Our Case Number: ABP-309770-21

Re: Proposed development of up to 15 wind turbines with a tip height of up to 175 metres and laying of approximately 26km of underground electricity cabling to facilitate the connection to the national grid, and all associated site development works
Townlands of Camagh, Carlanstown, Coole, Clonrobert, Clonsura, Doon, Monktown, Mullagh, Newcastle and other townlands, Co. Westmeath

23rd February 2023

2023 Further Information, Coole Wind Farm

Figure 13-2: UNESCO World Heritage Sites on tentative list in relation to EIAR site boundary and proposed turbines.

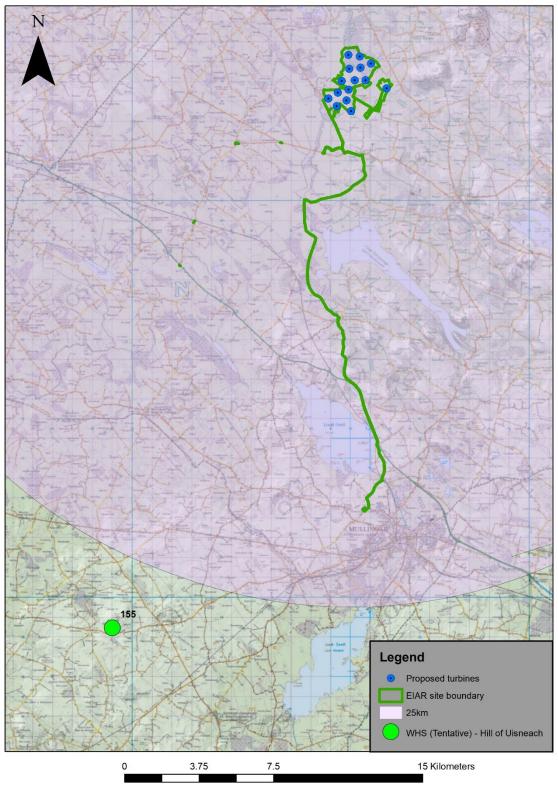
The CWF archaeologist looks at impact of the development on World Heritage Sites, National Monuments and Recorded Monuments, (Par 4.1.1) Tobar concluded that the Hill of Uisneach, 28km from the nearest turbine, would not be impacted. We disagree.

They fail to mention that the Hill of Uisneach was placed by UNESCO on Ireland's 'Tentative List' for UNESCO World Heritage Status. This was announced in July 2022. The Tobar report is dated September 2022.

Uisneach is part of a "tentative" list which is composed of 5 major archaeological sites, as follows- Macha in Armagh; Dún Ailinne in The Curragh, Kildare; the Rock of Cashel in Tipperary; and the Hill of Tara in Meath.

That's how important it is and its setting should not be jeopardised by the sight of industrial scale wind turbines, even on the horizon.

Figure 8A Wind Farm Site - Peat Depth Distribution

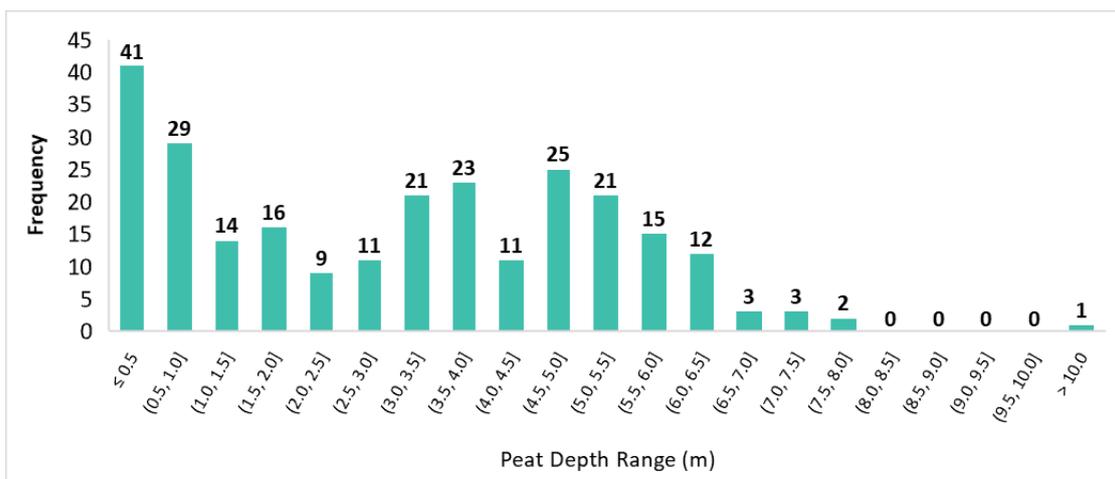
4.1 With regard to the peat depth at T12:

In 2020 MKO used a method of measuring peat depth called 'Rotary Core Borehole' and at T12 it gave a peat depth of 12.5 metres.

In 2022 MWP Engineering used a 'peat probe' method to test peat depths and at T12 gave a depth of 8.7-9.0 metres. A difference of 3-4 metres.

MWP Engineering say this difference is because the Rotary Core Borehole process cannot tell the difference between soft peat and a soft limestone clay found underneath the peat – when two soft substances meet the soft clay feels like soft peat and it becomes mixed up.

If a peat probe is a more accurate form of measuring peat depth then why have CWF not used this method in all turbine locations? There is a difference of almost 4 metres at T12. This is significant.

8.7 – 9.0 metres depth of peat is still very deep. Can CWF SID guarantee that there will not be issues with stability at this depth?

Will the soft clay underlying the peat make the location for T12 even more unstable?
